Application Ref:	3/2026/0401			 Ribble Valley Borough Council www.ribblevalley.gov.uk
Date Inspected:	19/06/26	Site Notice:	19/06/26	
Officer:	AR			
DELEGATED ITEM FILE REPORT:				APPROVAL

Development Description:	Proposed demolition of existing porch and erection of new larger porch. Formation of new window openings and internal alterations.
Site Address/Location:	5 New Row Cottages Clitheroe Road Knowle Green PR3 2YS

PROPOSED ELEVATIONS

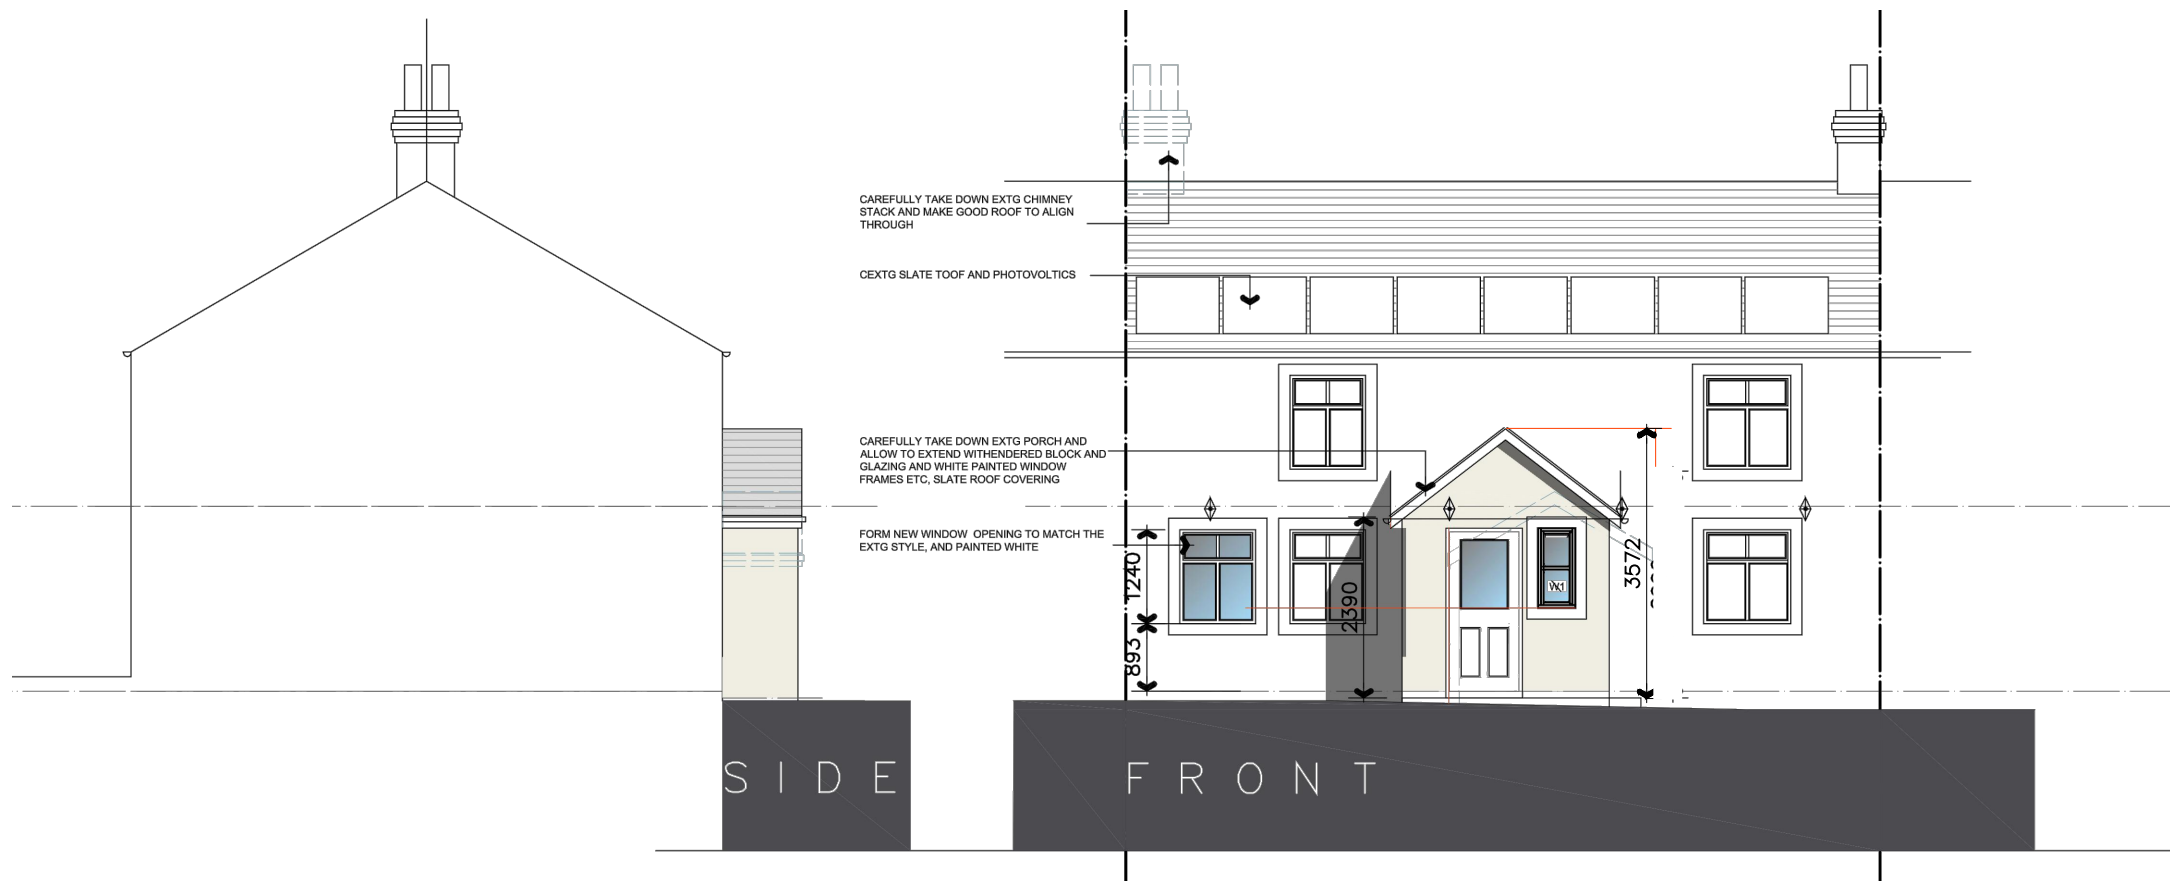
The proposed development would be highly visible from PROW FP0335001, when approaching the dwelling from the west and east. It is considered that the proposed porch would not reflect the local vernacular and style of the existing street scene, making the building appear out of context with the surrounding built form, particularly the New Row Cottages, which are characterised by traditional features such as timber windows and doors. The proposed porch appears to lack a cohesive design approach, with a mix of contemporary and traditional features. As such, it would be considered that the proposal would not accord with Policies DMG1 and DMH5 of the Ribble Valley Core Strategy.

Furthermore, with respect to the two proposed window openings on the front and rear elevations, after desktop analysis and a site visit, it has been concluded that the window arrangements in the street scene vary, and therefore they would not be read as an incongruous addition to the dwellinghouse.

With regard to materiality, the proposed porch would feature render to the elevations, with blue slate roof tiles and a white painted timber-framed window. Whilst the proposed window to the dwelling’s front elevation would feature a white painted timber frame, the window to the dwelling’s rear elevation would feature an oak-stained window framed to match the existing.

However, amended plans have been submitted to include a pitched roof and to alter the proportions and style of the openings to better suit their surroundings. Consequently, concerns regarding the design of the proposed porch have been addressed, and it is now considered a modest addition that matches the unique architectural design of New Row Cottages and accords with the relevant planning policies.
